RE: WEST CULBURRA MOD1 RFI

Martens and Associates (**MA**) have prepared this letter in response to a request for information from Shoalhaven City Council (reference D25/429779 dated 1 October, 2025) regarding the Mod 1 application for the West Culburra mixed use development, approved under SSD 3846, at Lot 1, DP 1305809 in West Culburra (the **Site**).

**TYPICAL 8m ROAD IN 25m ROAD RESERVE CROSS SECTION
FOR ROAD 02 WITH WATER QUALITY CONTROL**
SCALE 1:50

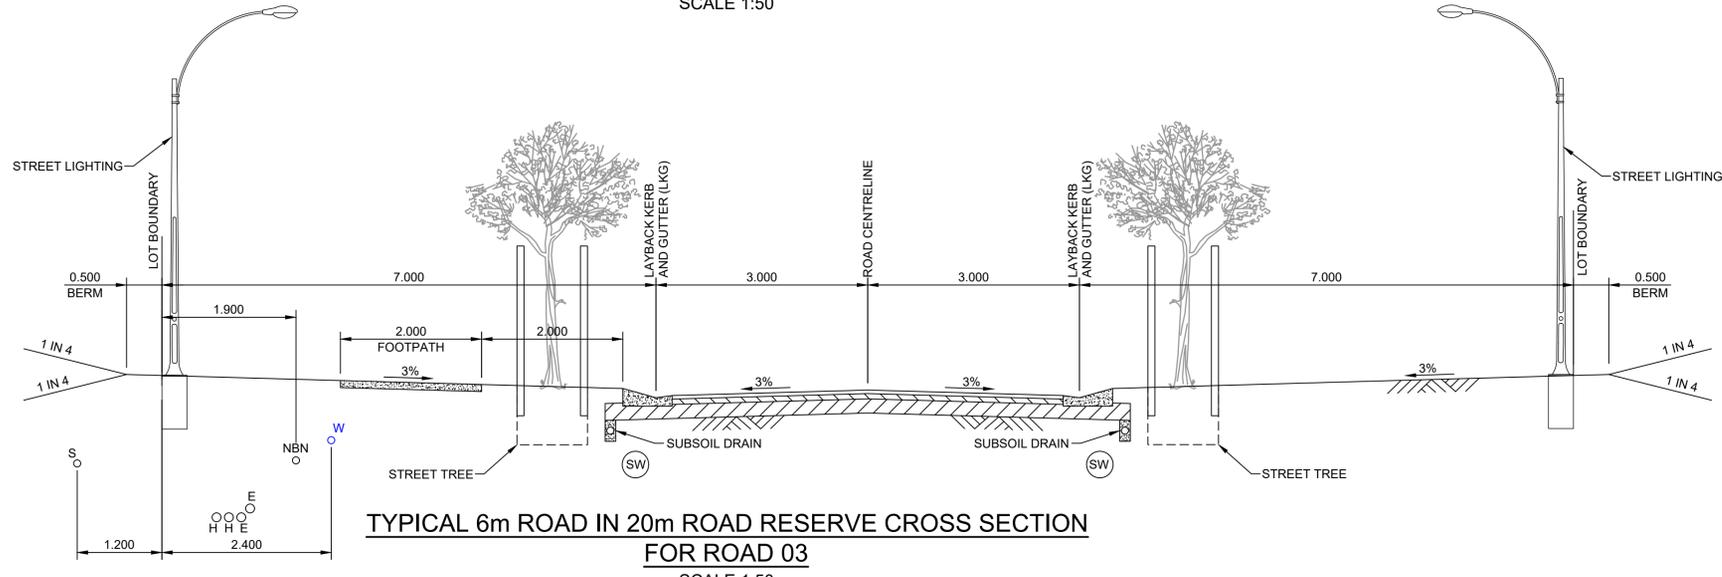
1.7 8th dot point – Grassed swales in MUSIC model

Swales included in the developed conditions model for Mod 1 are consistent with those provide in the SSD IWCMS MUSIC model. The inclusion of these structures in the engineering design plans is considered a matter for detailed design which shall be addressed by the site designers at a later stage.

To assess the significance of the swales the assessment model [P2209097MUS04V32] was rerun without the swales. The effect on pollutant loads to the Crookhaven River were minor, with very small increases in TSS, TP and TN. Results with or without the swale still achieves NorBE in accordance with the SSD IWCMS (Table 1).
